Consultation Response from: KC Environmental Health (Pollution & Noise Control)

2025/92443 - Huddersfield Open Market, Brook Street, Huddersfield, HD1 1DY

**Responding Date:
01 October 2025**

**Responding Ref:
WK202528796**

Figure 2: Noise measurement positions (P1 and P2)

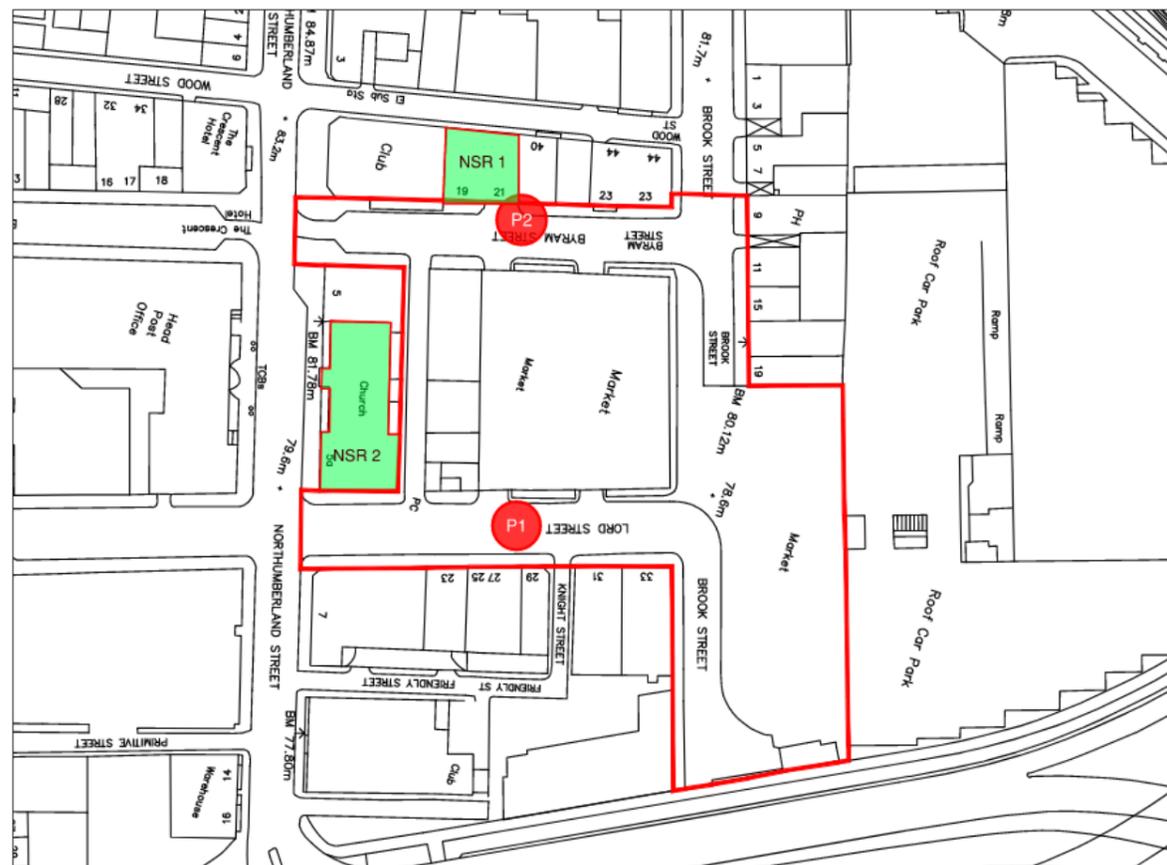
A 24-hour baseline noise survey was undertaken on the 20th and the 21st of May 2025 from two monitoring positions (P1 and P2), shown in Figure 2 which also shows the nearest noise sensitive receptors (NSRs). A summary of the results is given in table 5.

Figure 5: Building sound contours, showing the calculated MNLs, L<sub>Aeq, 15min</sub>

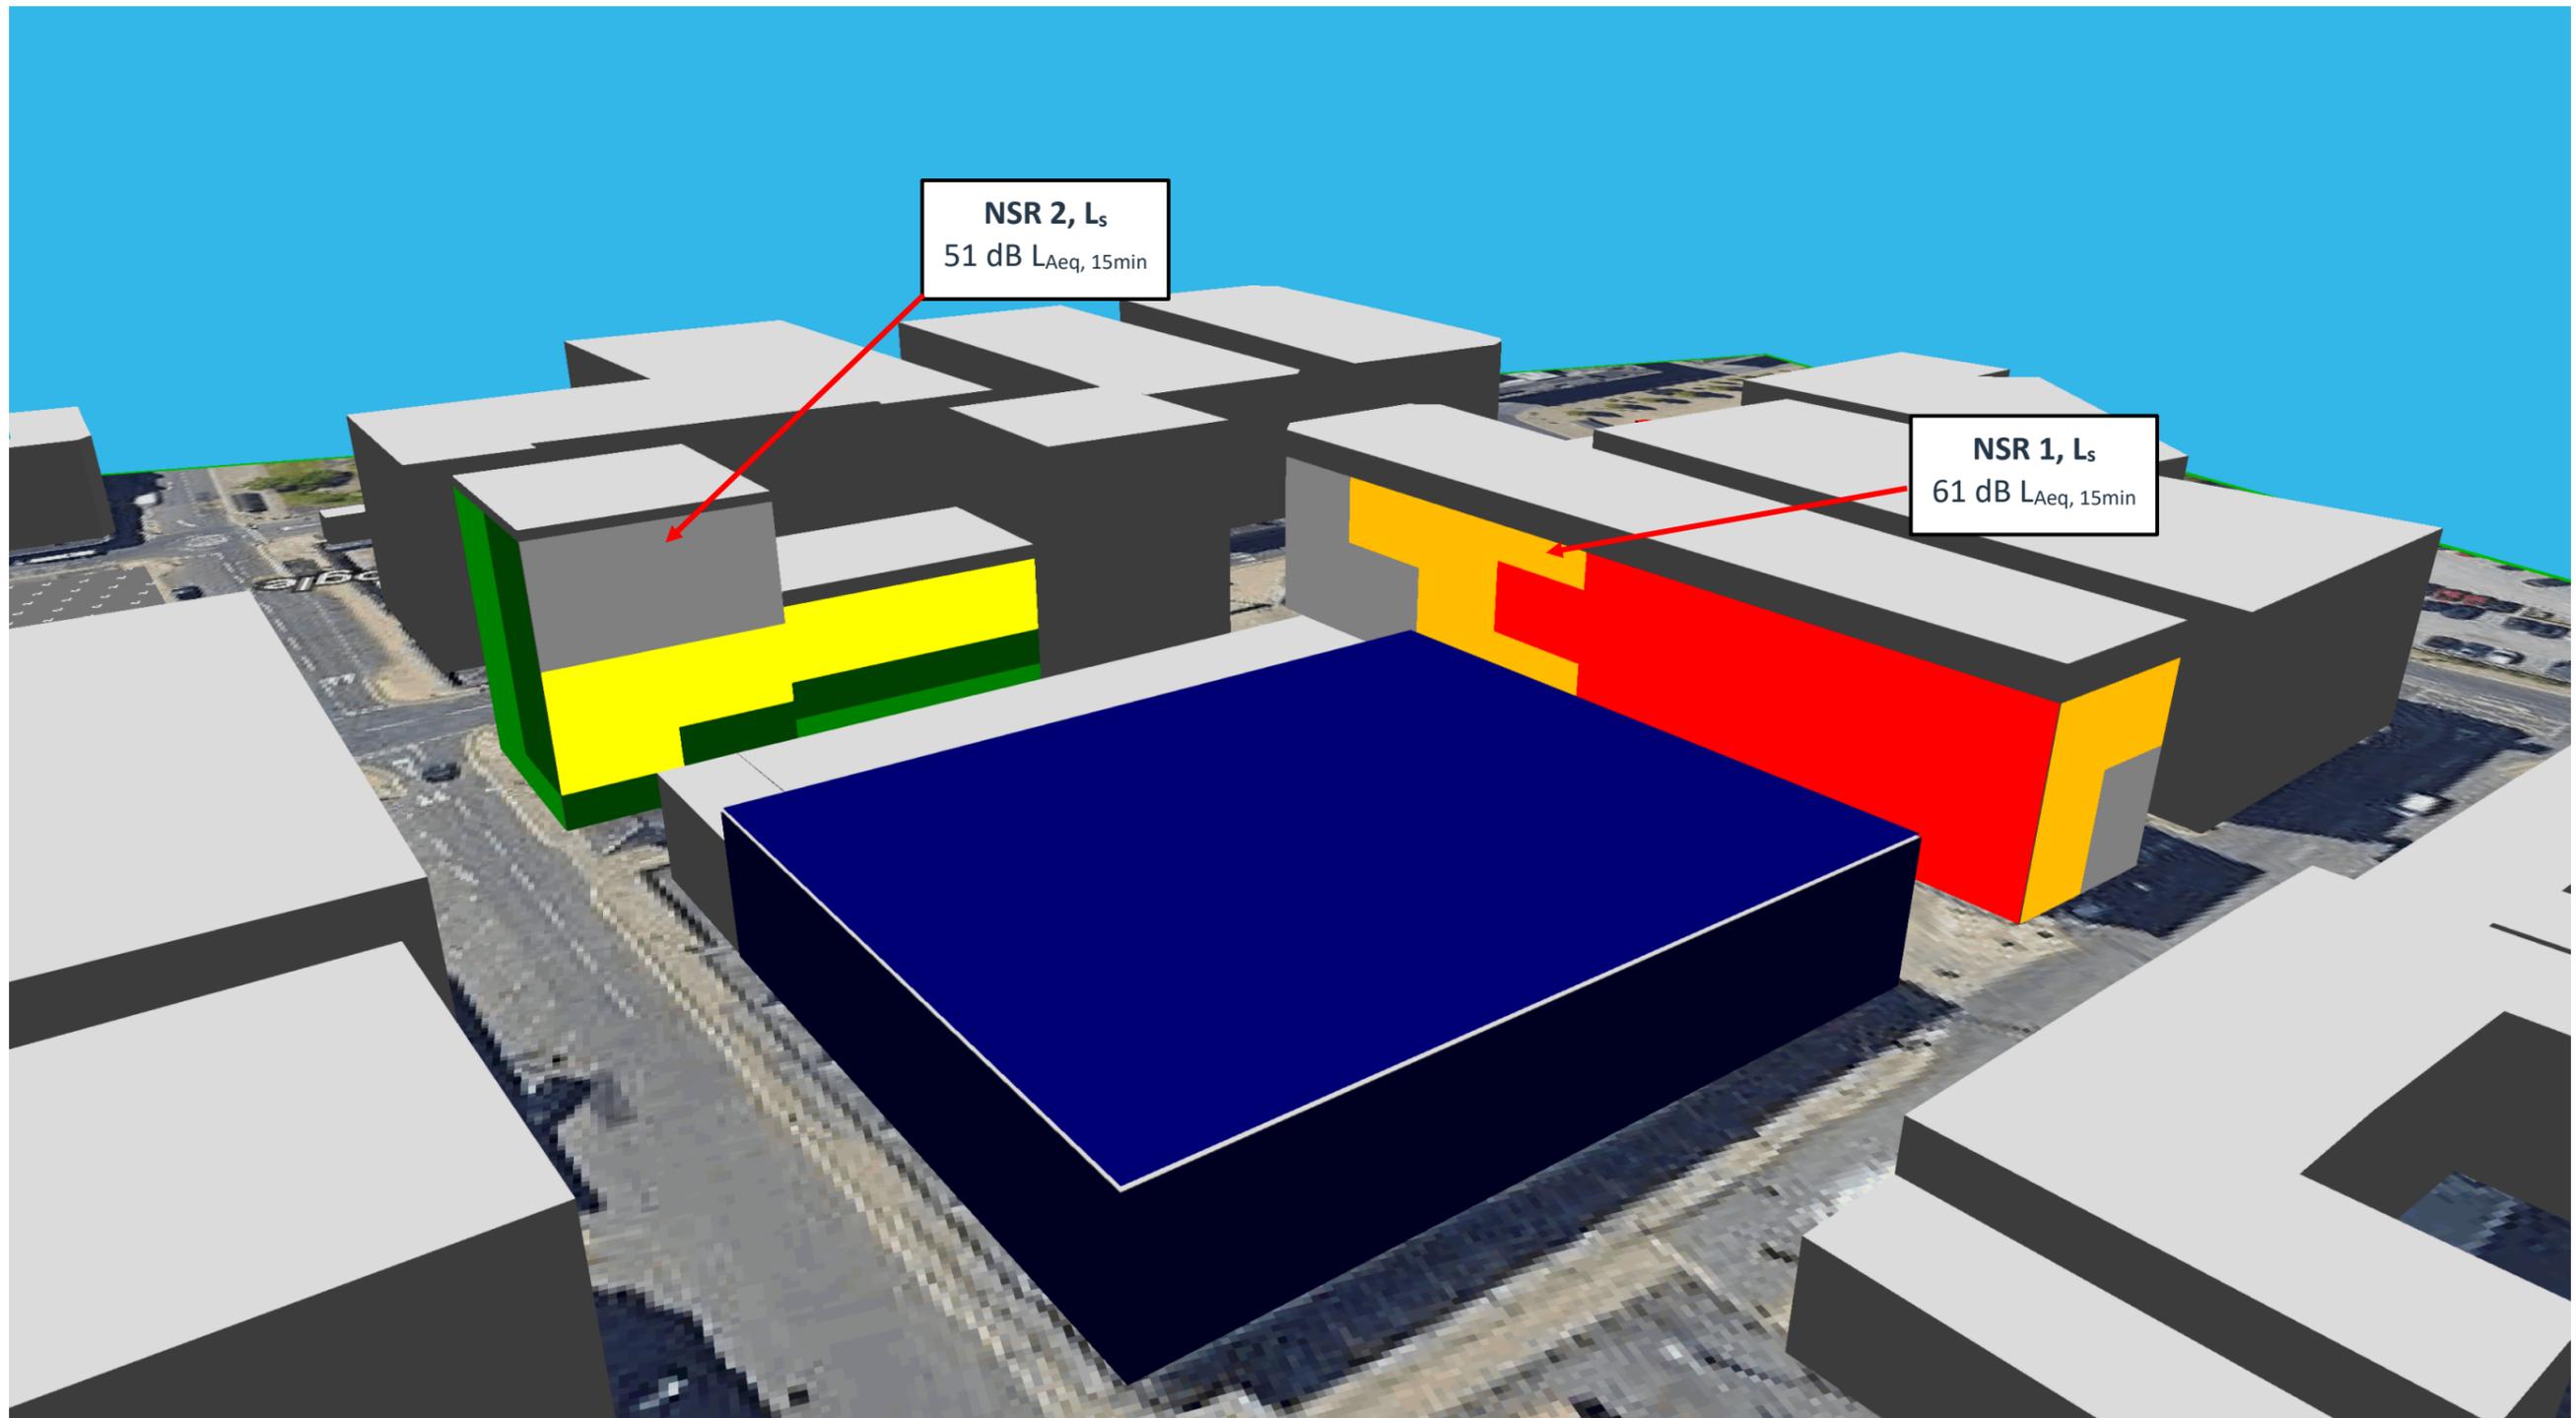
Modelling has been conducted based upon library data for a music bar and the resultant figures in table 12 indicate a low impact to both NSRs. This is assumed to be based on all doors being kept closed but it is not stated and so we ask that this be clarified. Comment is

made that access/egress should be restricted to Lord Street and Brook Street but there is an identified NSR at Brook Street and we ask what impact noise breakout from access/egress will have on this occupier.

The market hall is highly reverberant based upon the glass and concrete structure and the author caveats the report in para 7.13 by stating the results should be verified during the first few events at the identified NSRs, to determine if internal reverberant noise levels in the Open Market Hall must be limited at the Front of House, for certain frequencies. A condition is recommended for a further/addendum report to be submitted based upon monitoring for the first few events and it is for the Planning Officer to determine the timings.
